Martin Nugent
01254 828060
D3/11/0837

Drafted 24 January 2012

**Planning Application, Ribble Valley District
D3-11-0837 land off Pendle Drive, Calderstones Park, Whalley**

10-094-HT04-2

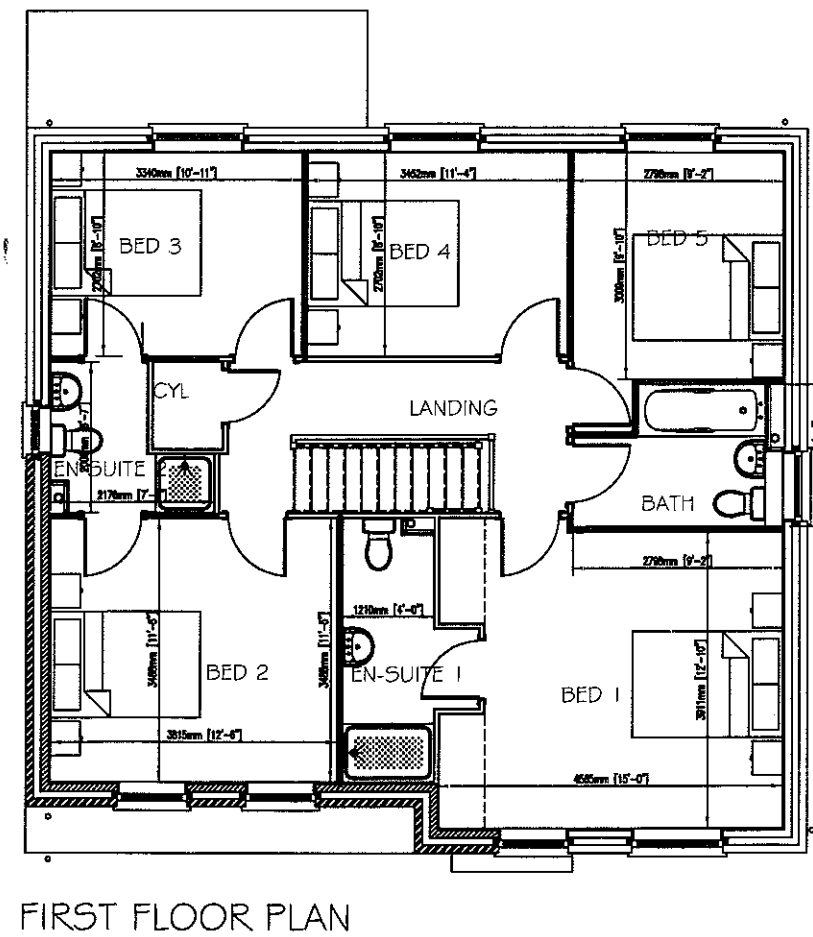
On this basis, the layout of garage design D914 at 2.56m by 5.05 is acceptable as the full internal space is available for the vehicle. Similarly, D1337, at 2.57m by 5.45m is also acceptable

However, I would request that the following Condition should be attached to any future consent your Committee may provide in respect of this application;

1. In order to retain the use of this space for the garaging of a private vehicle, the future development of this amenity for residential space or for exclusively storage purposes is to be prohibited.

10-094-HT05-2

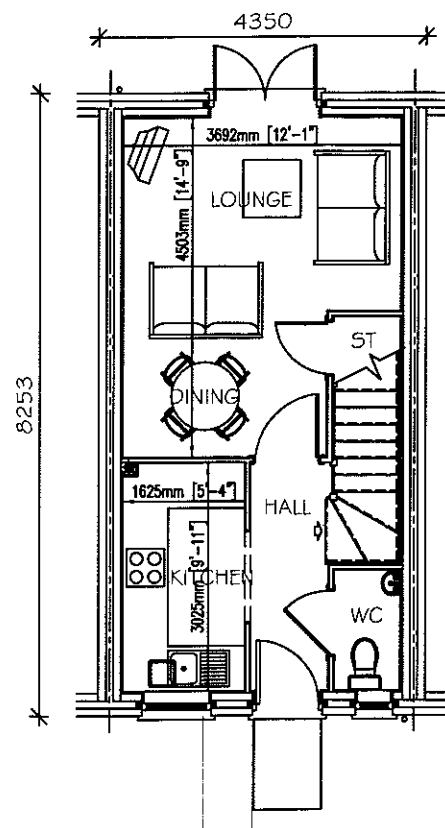
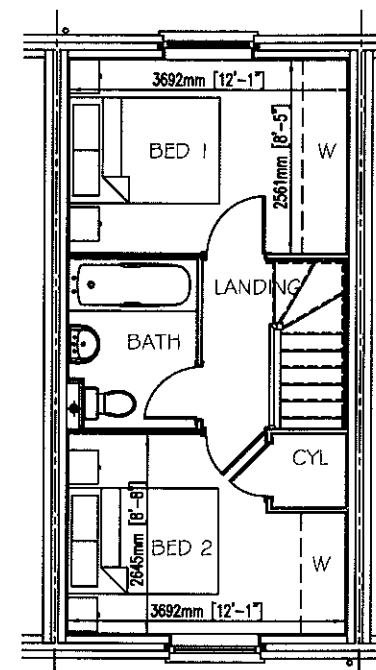
The double garage design for D1651 is detailed at 4.9m by 5.09m. Once again, as there are no inhibiting factors within this space the layout is acceptable to provide a safe and effective car parking area.
